facsimile transmittal

Re: Ocean Ridge units 1,2,3 & 4

I have my completed the initial review and have the following questions/comments:

**S9**

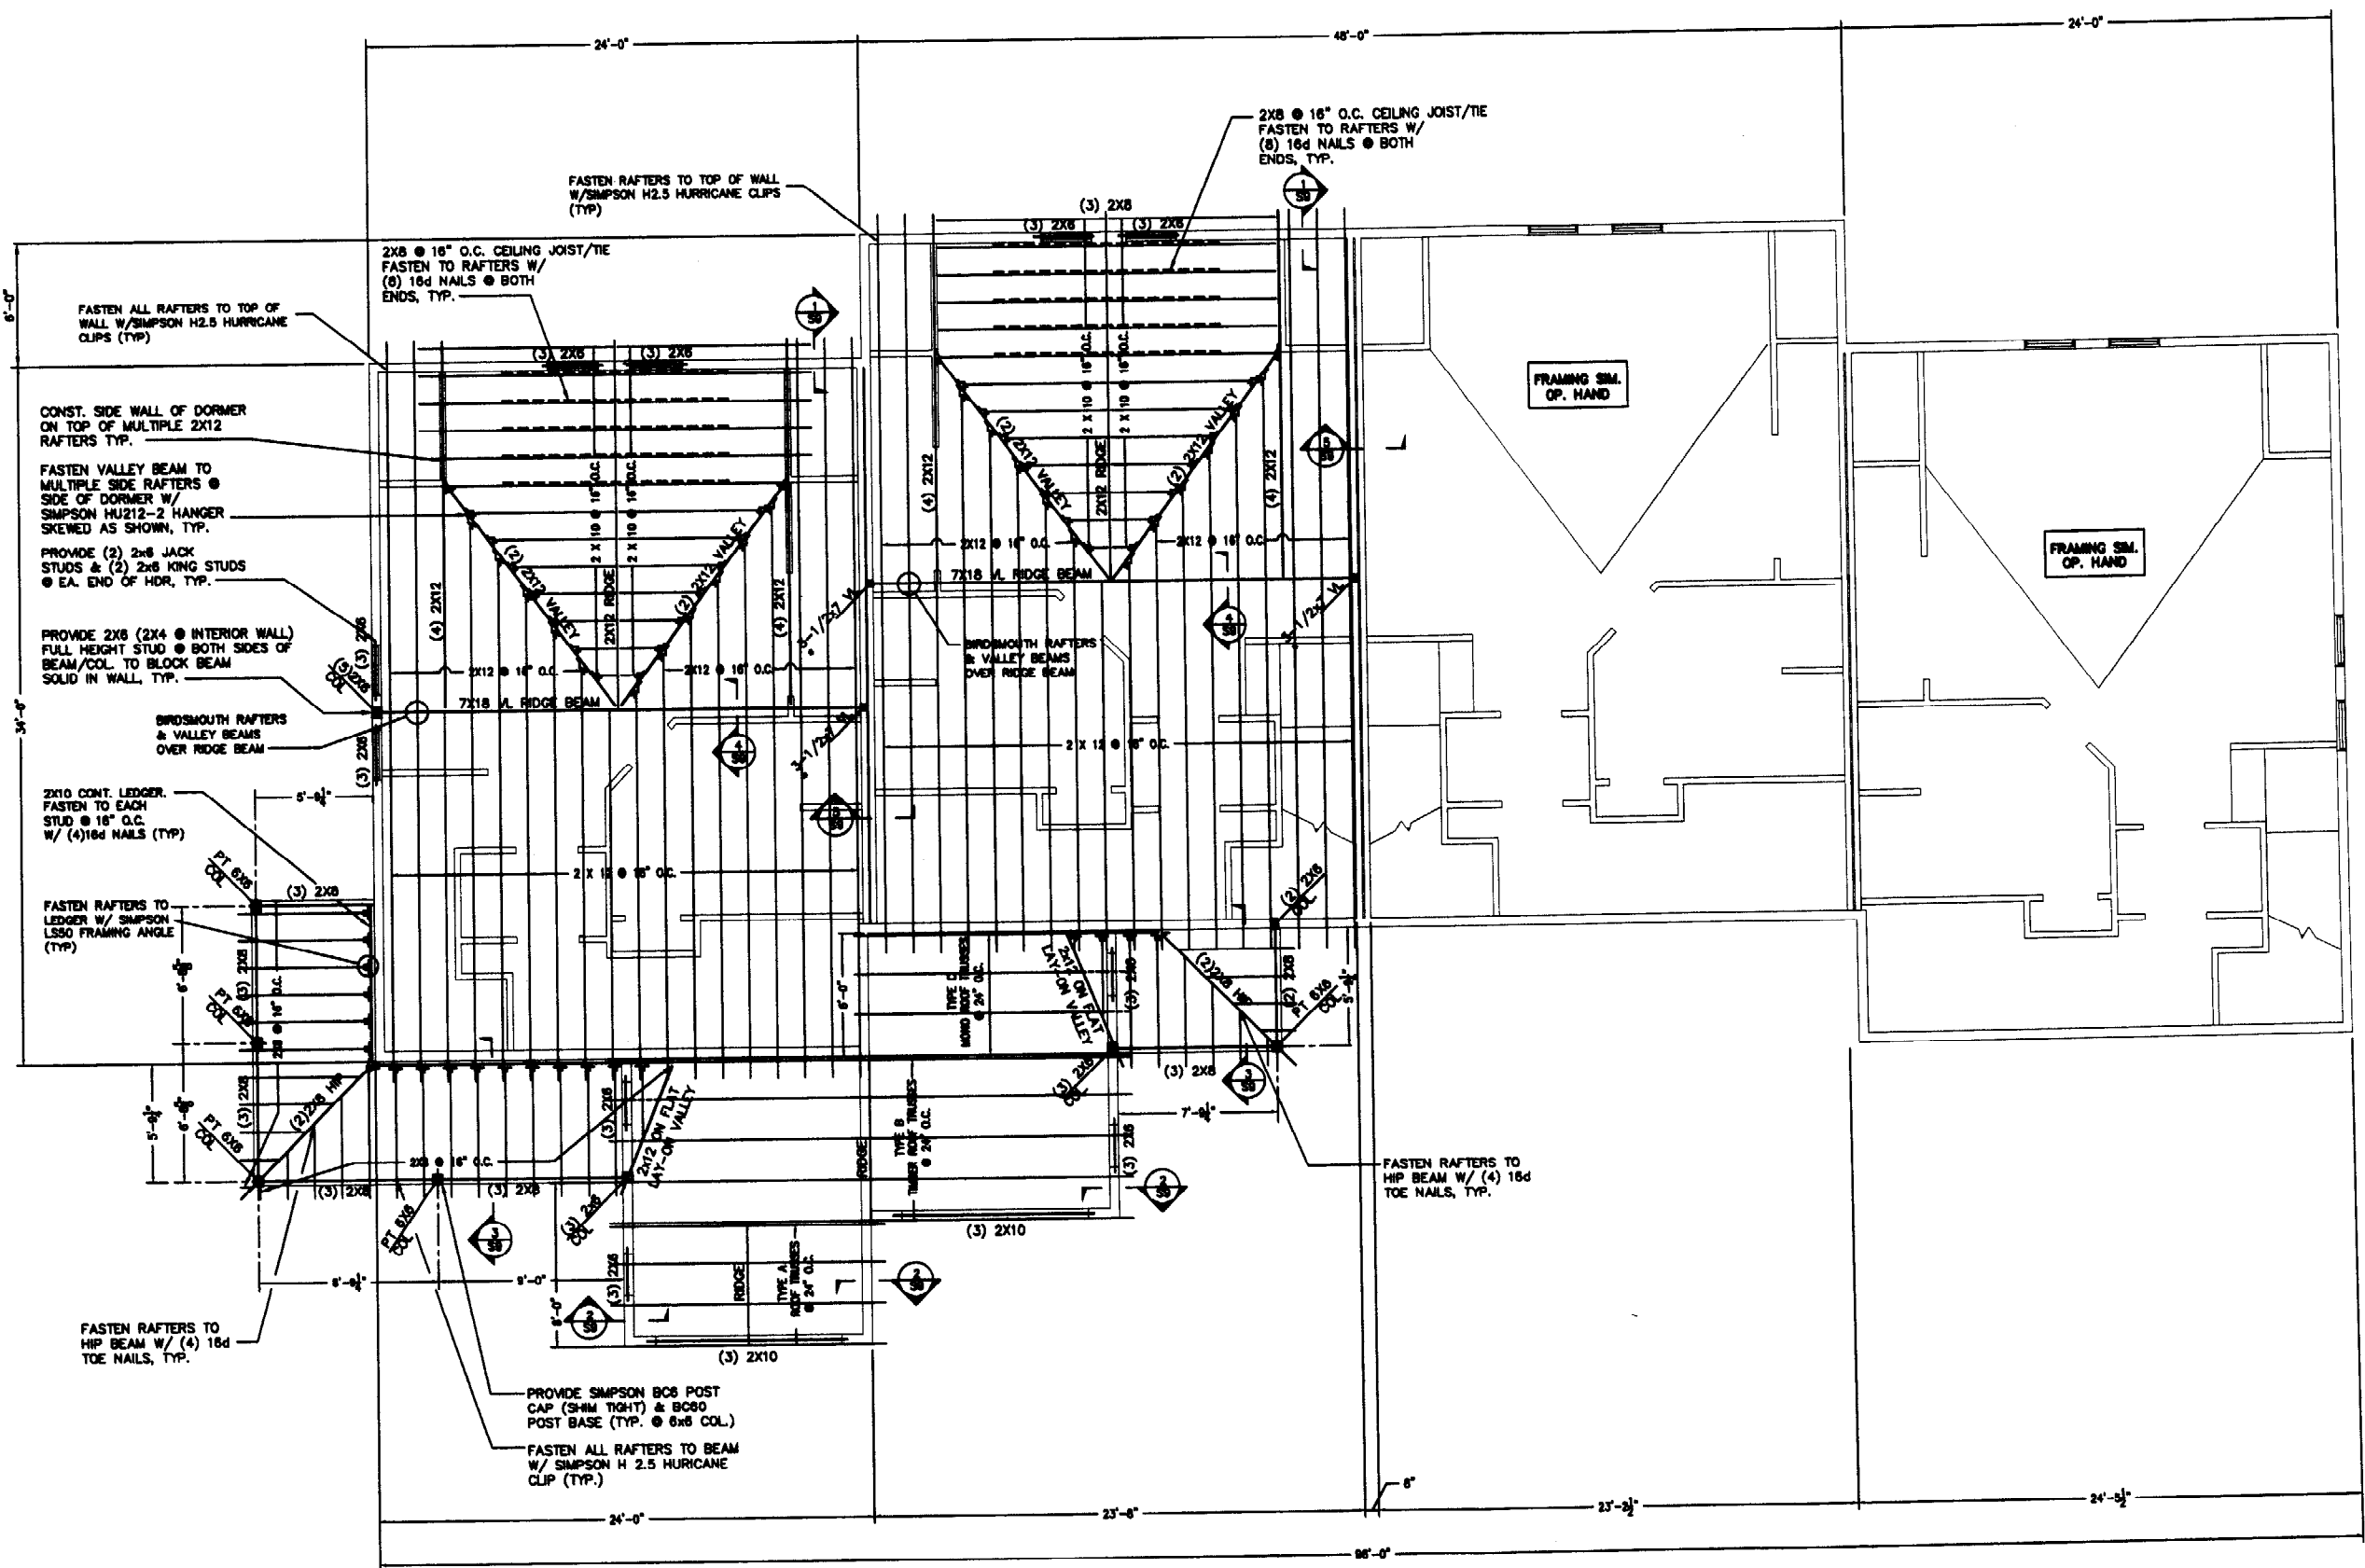
- 9) Does the wall system extend to the underside of the roof sheathing?
- 10) What is the STC of the wall assemblies?
- 11) Page S9 Figure 5, using the FTW product, does the fire rated assembly include the GWB on the underside of the floor? (see section 711.4)

**A4**

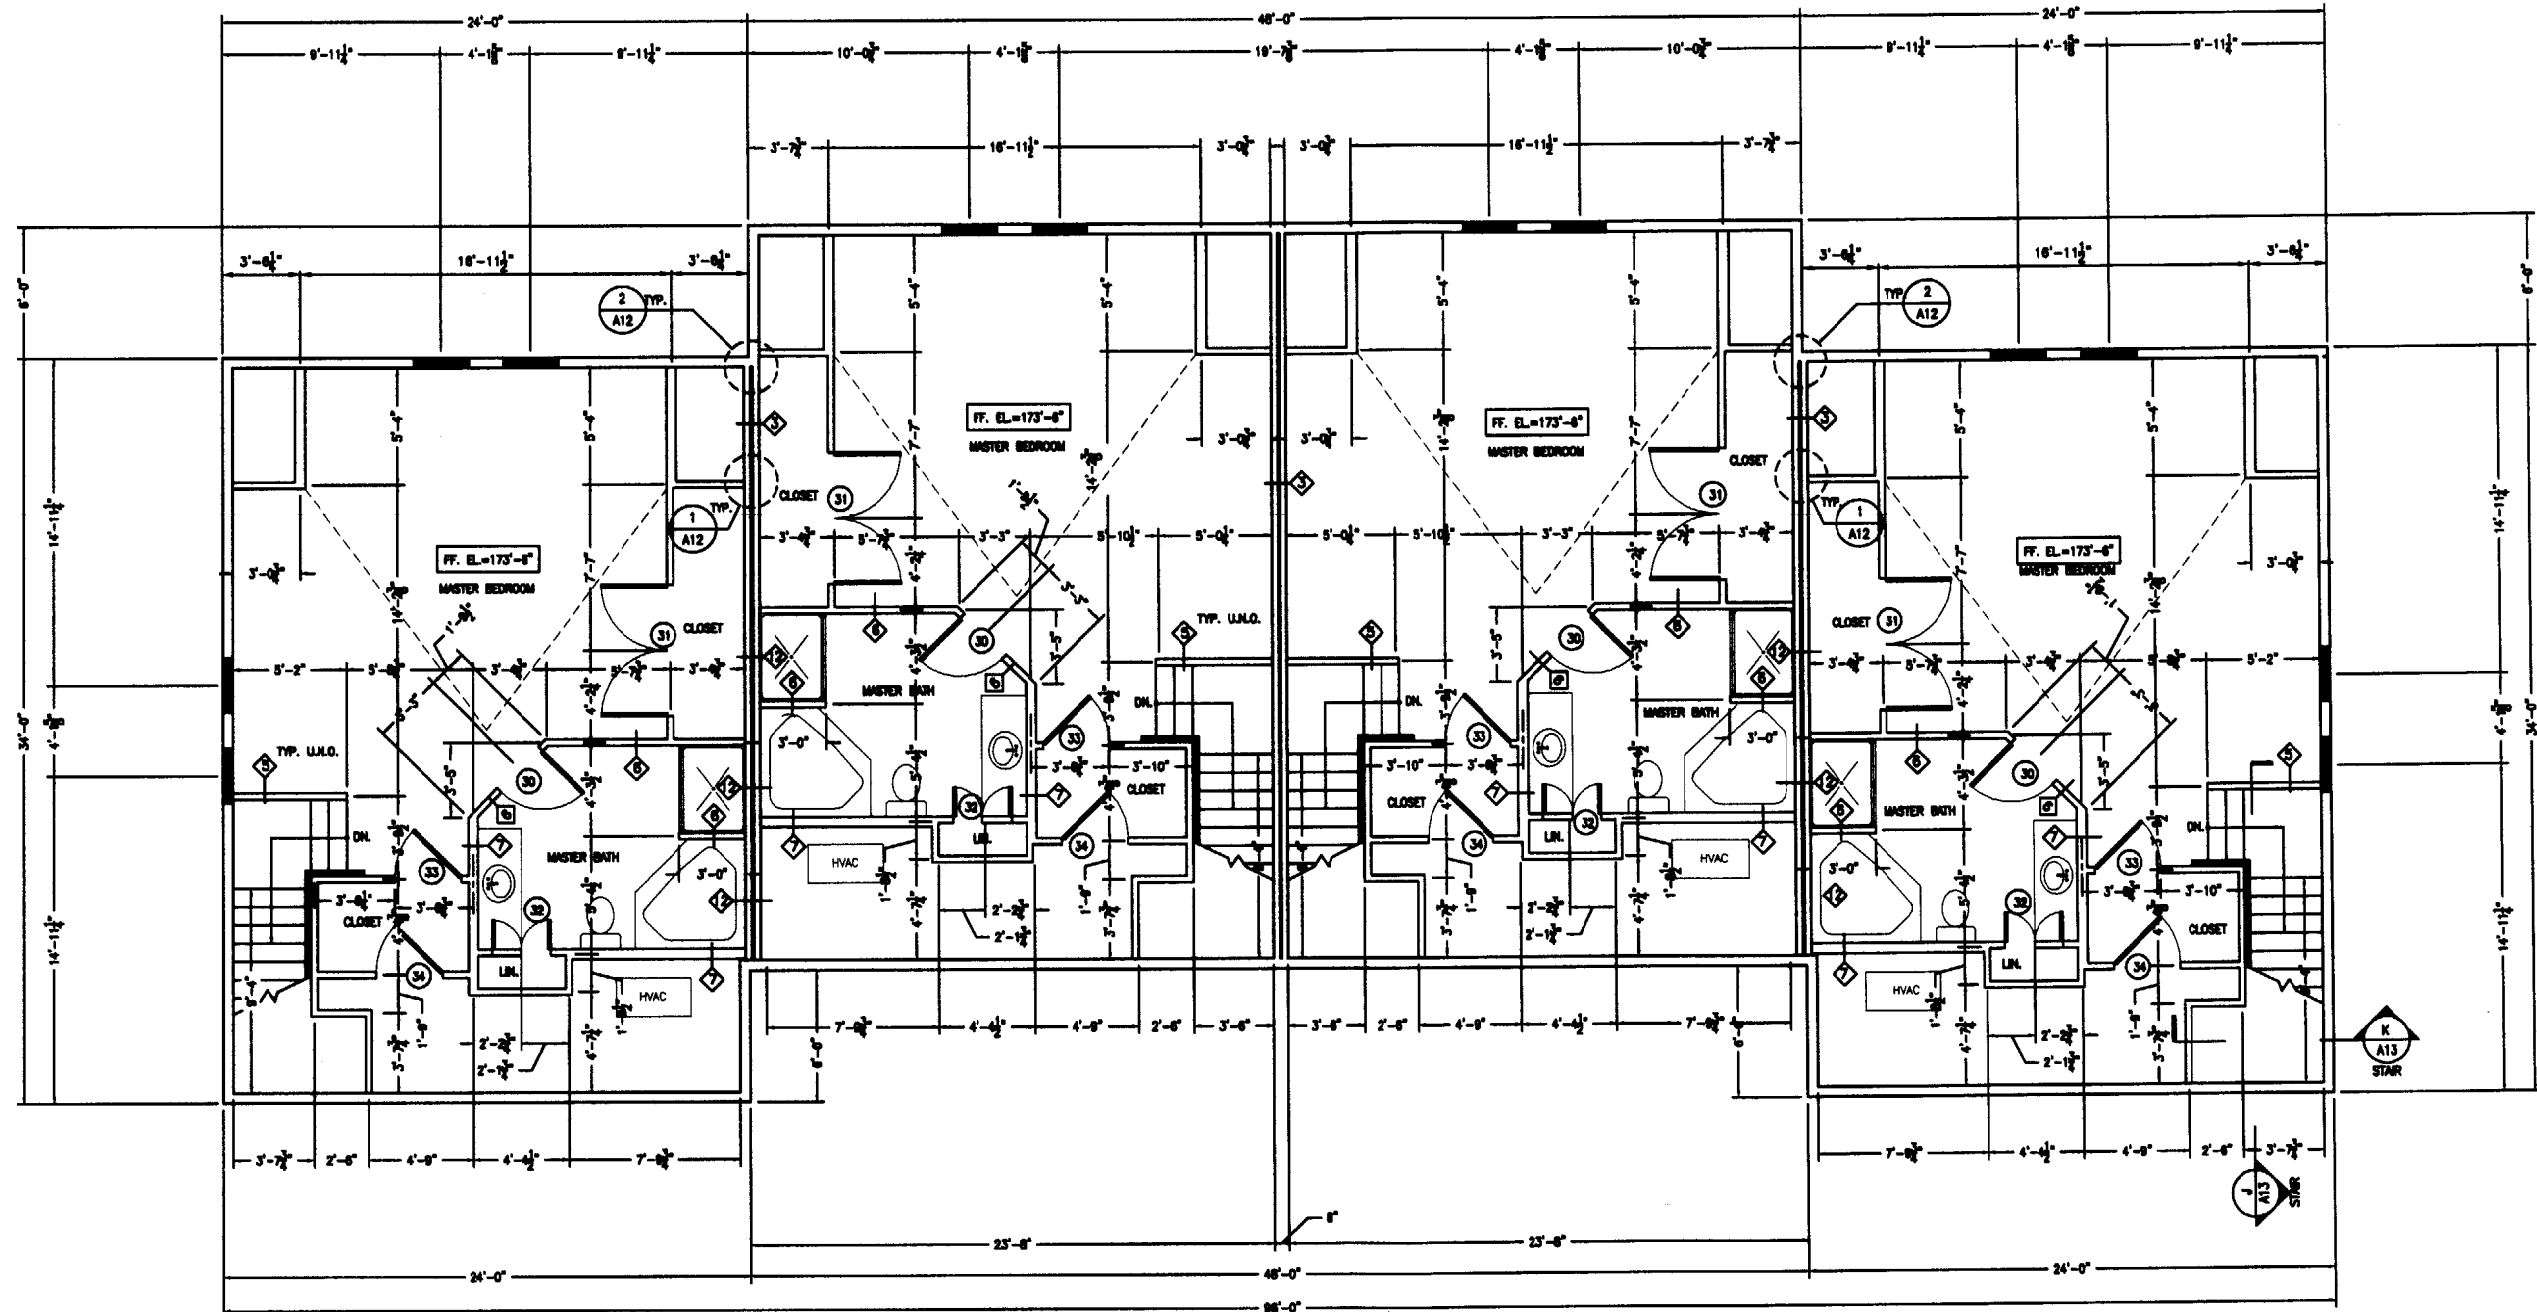
- 5) ~~Will require separate permits and technical info about fireplaces and heating equipment.~~
- 6) The space between the third floor ceiling joists and rafters exceeds 30 inches and no attic access is shown.

A2

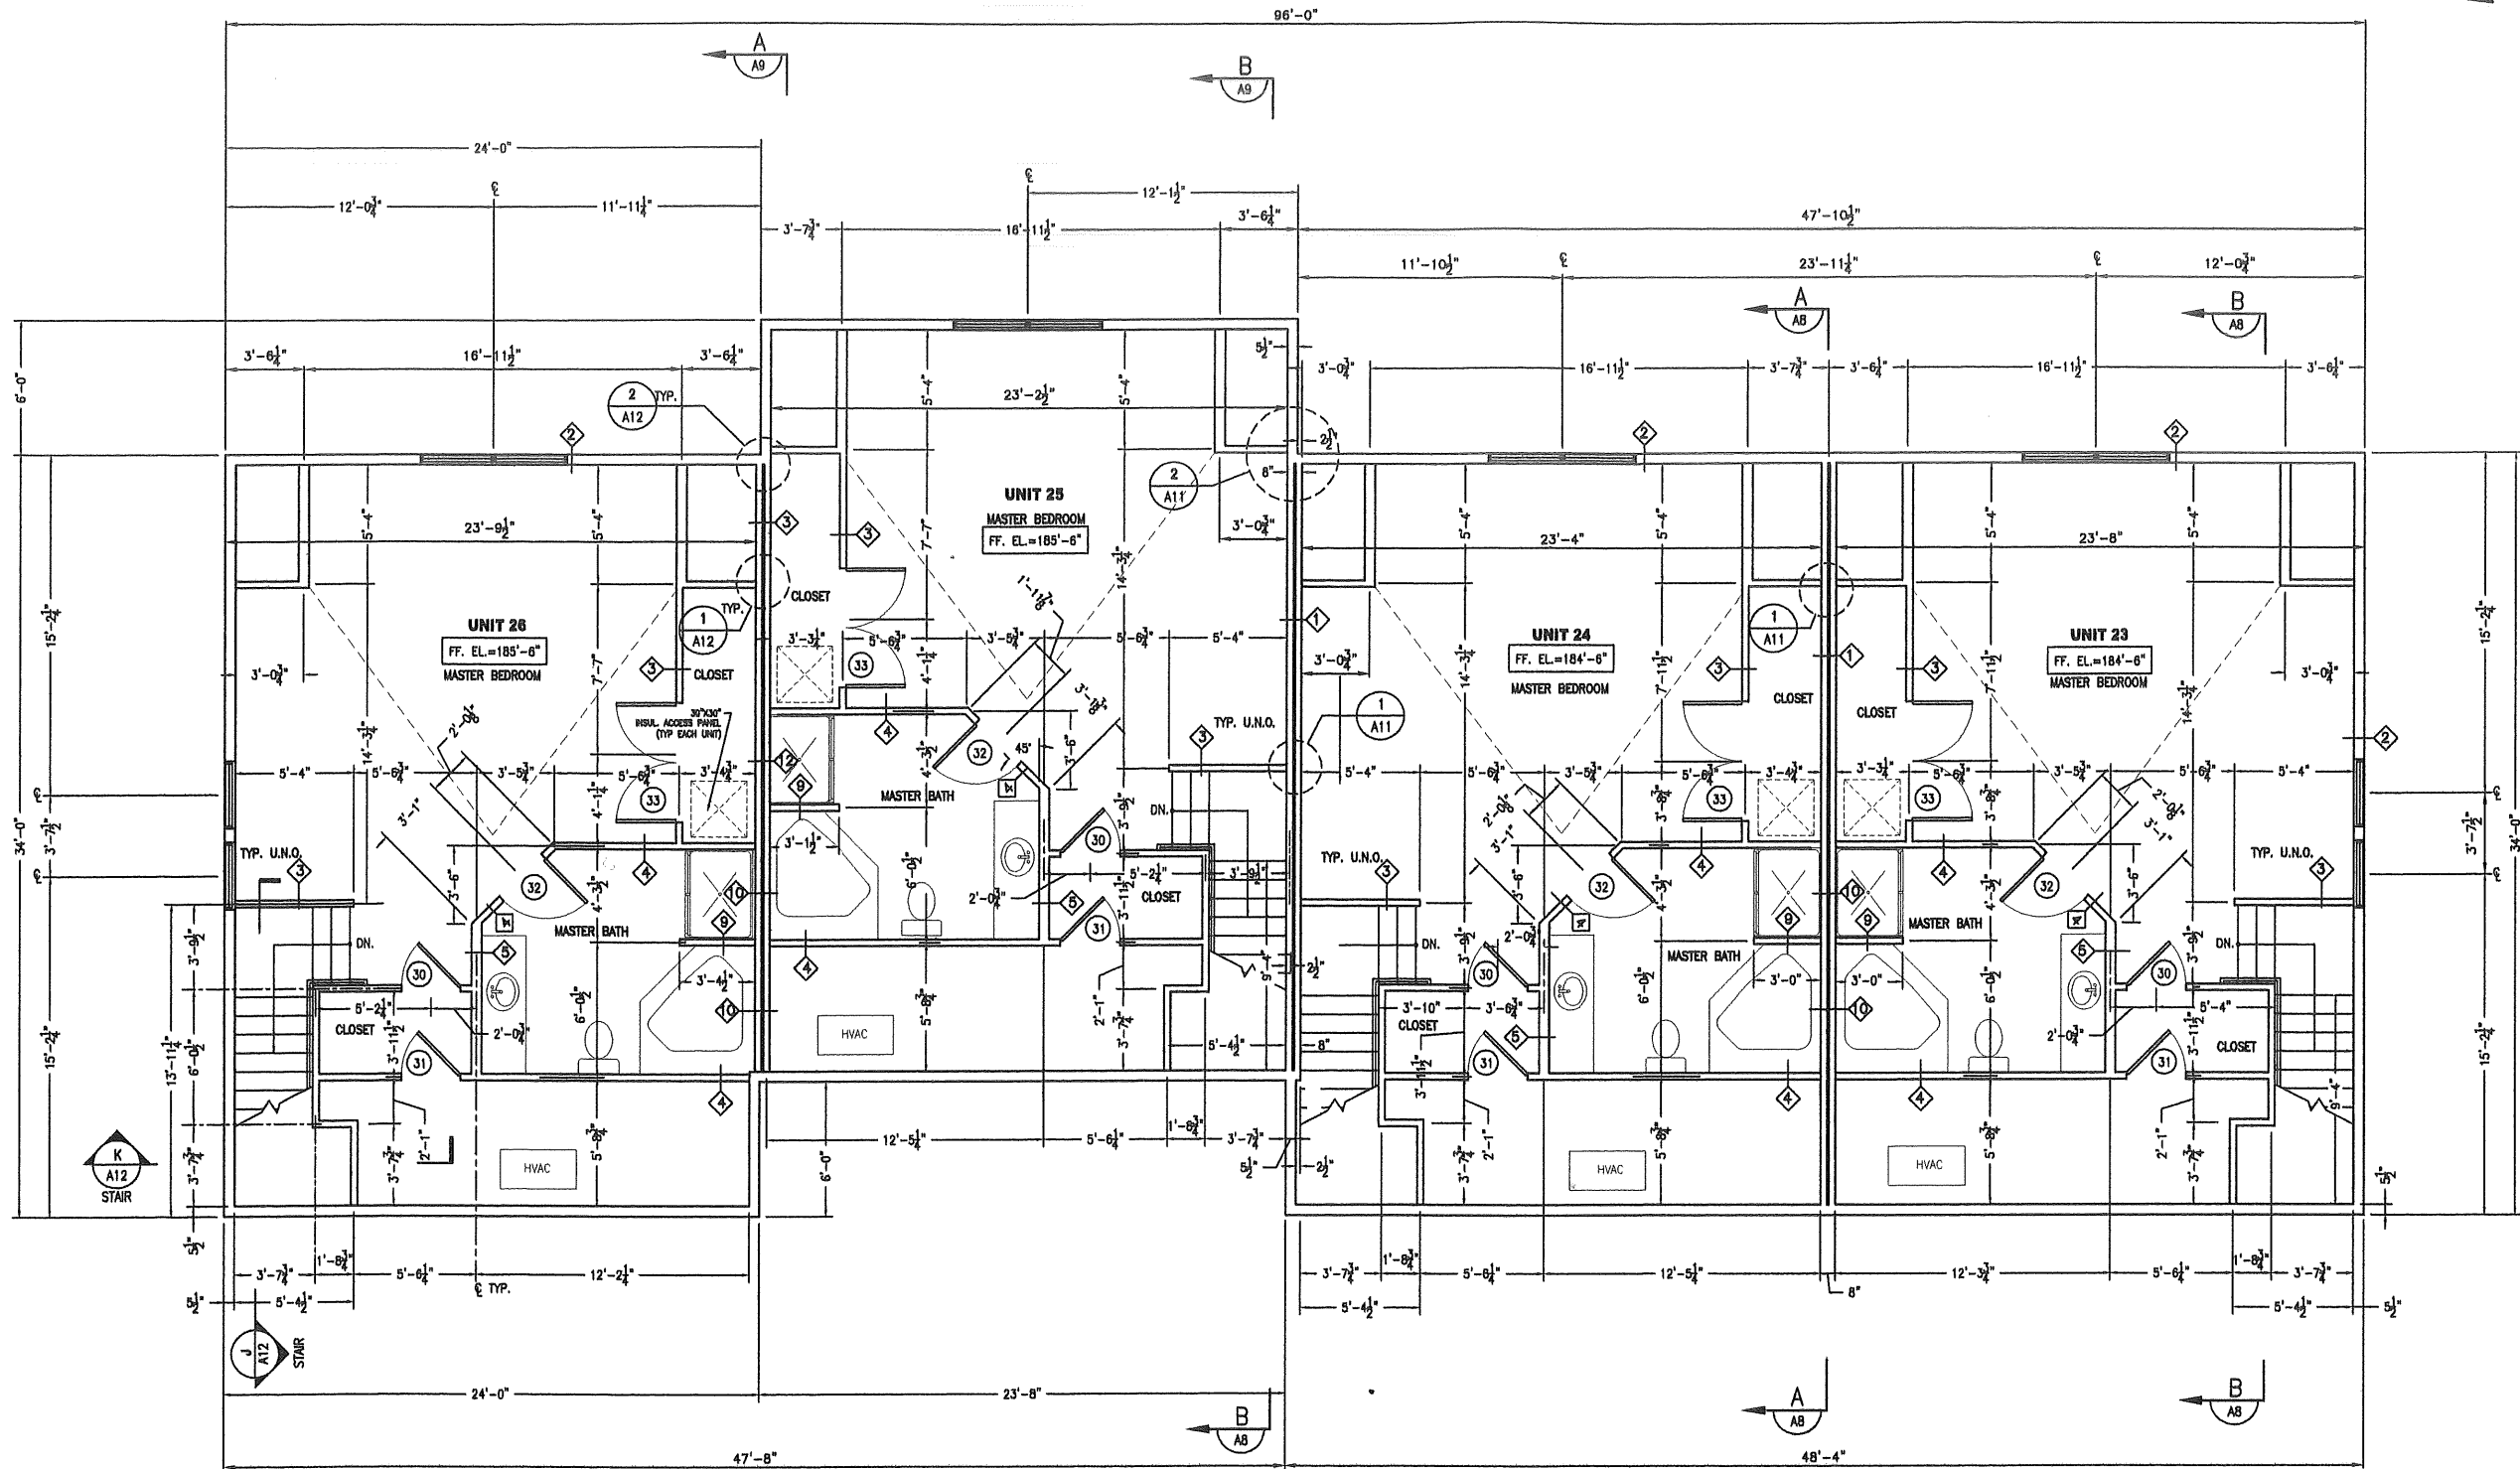
- 1) What is the spacing of the anchor bolts from corners?
- 2) Lally column type?
- 3) What type of Fire suppression system will be used?
- 4) Door "04" shown on page A2 is not on the door schedule, tempered glass?
